Application for Removal or Variation of a Condition following Grant of Planning Permission or Listed Building Consent

Demolition of existing barns and erection of a single replacement dwelling to superceded planning permission 16/00468/FUL

18/01697/FUL

1 (the approved plans) and 9 (the approved materials)

Scale	Date
1:100@A1 (1:200@A3)	Oct 2018
Drawn	Checked
naw	
Drwg No.	127-001
	A

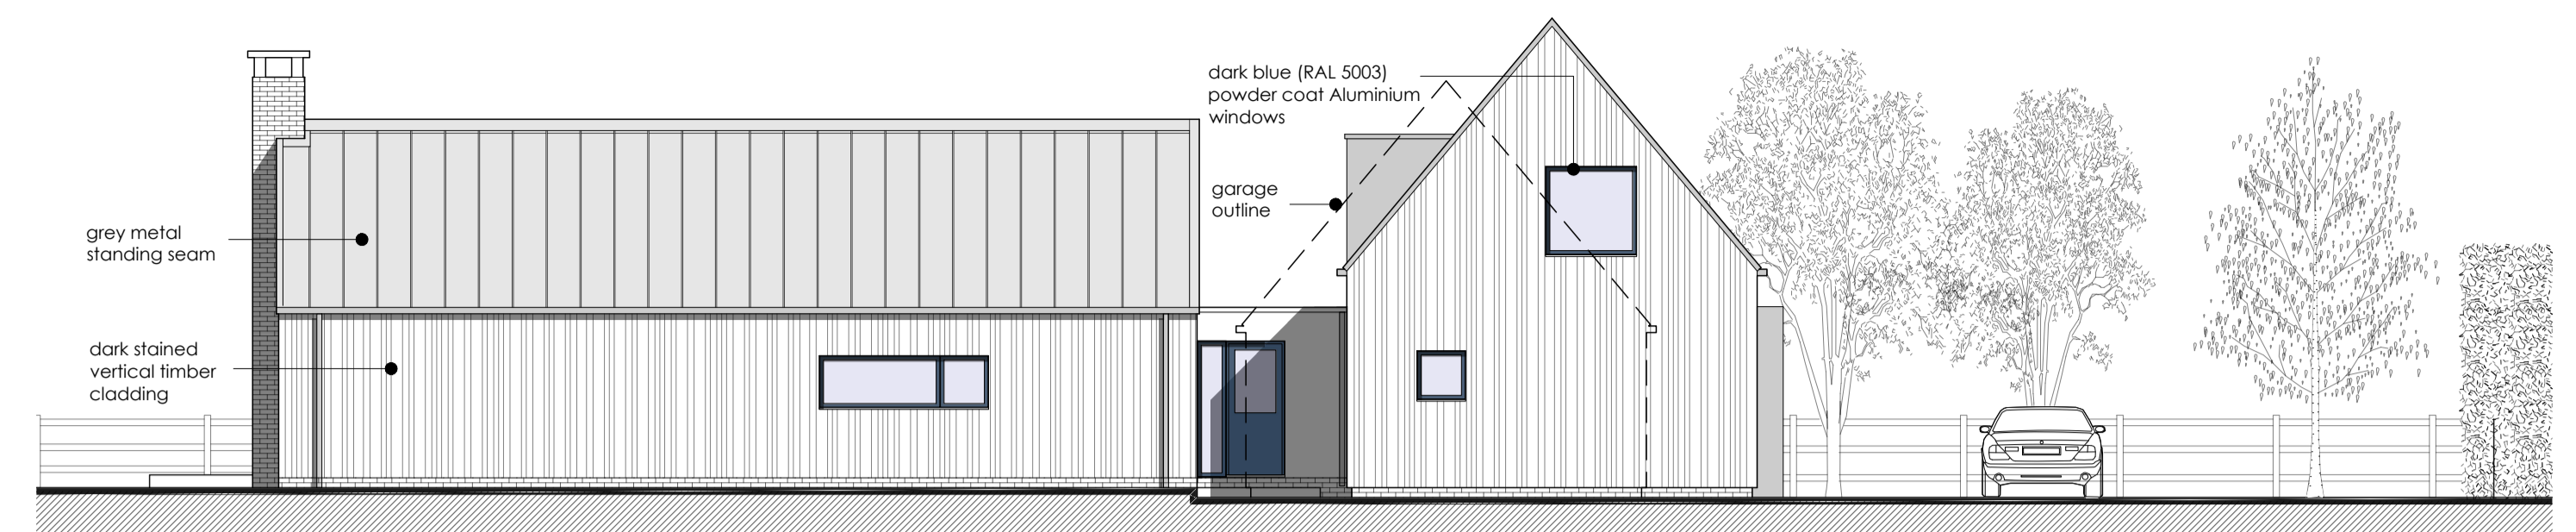
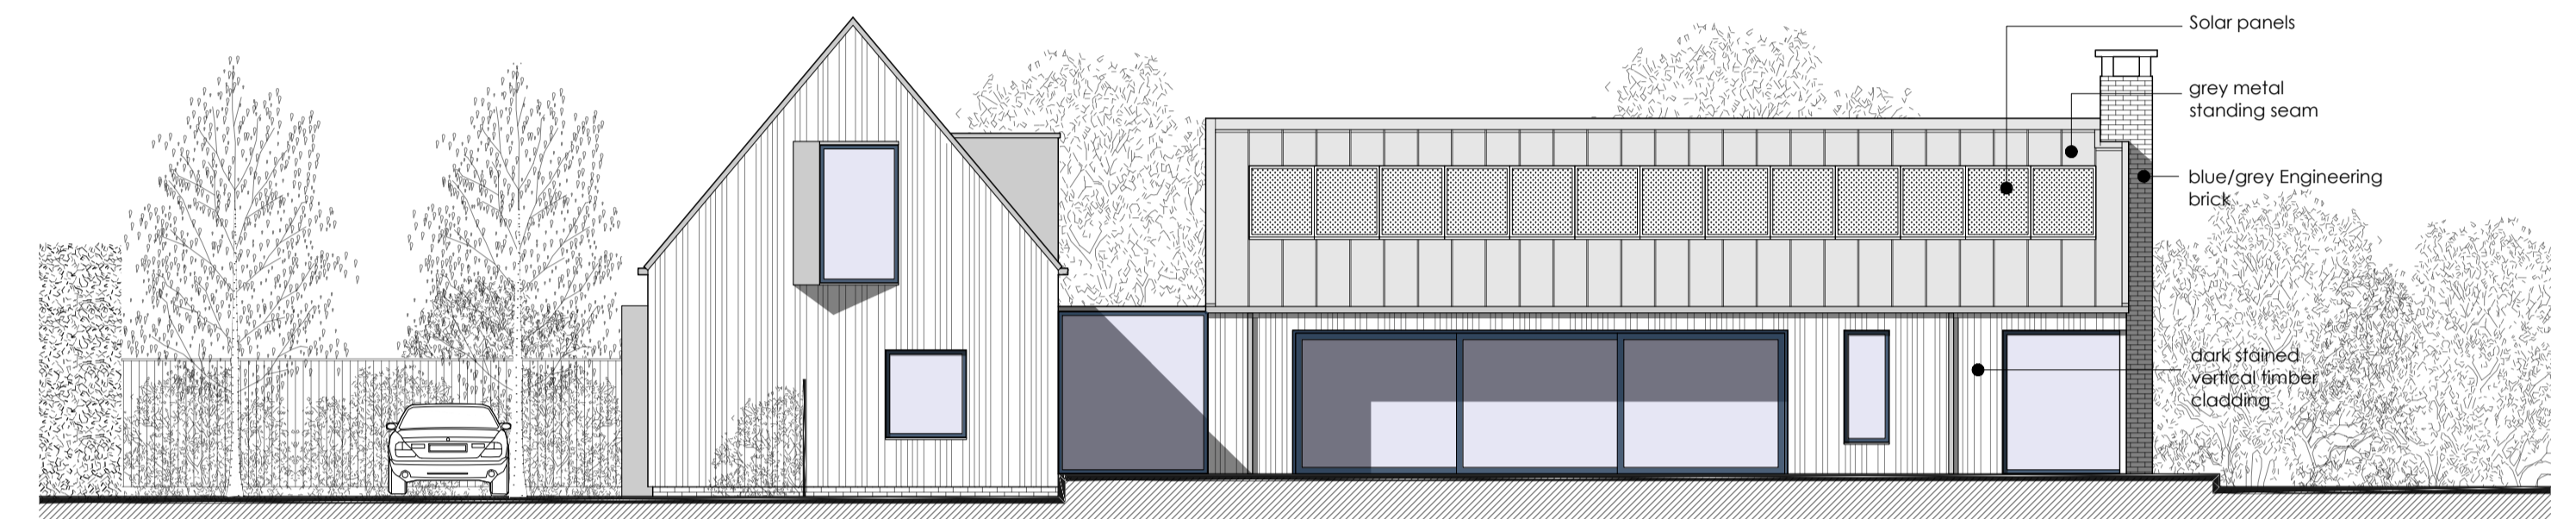
Condition 1: to replace drawing no. 127-001 with an updated drawing, no. 127-001A which changes the references of 'through colour render' on the south wing to 'dark stained vertical timber cladding' (to be common with the north wing) and also changes the references of windows from 'Dark Grey' to 'Dark Blue'. The chimney is changed from 'through colour render' to 'blue/grey brick'.

Condition 9: To update the materials specified in that condition to 1) dark stained vertical cladding, 2) dark blue powder coated aluminium windows, 3) grey metal standing seam, 4) blue/grey brick chimney. To update the drawing no. reference from 127-001 to 127-001A. To remove the reference to the e-mail dated 15th February 2019.
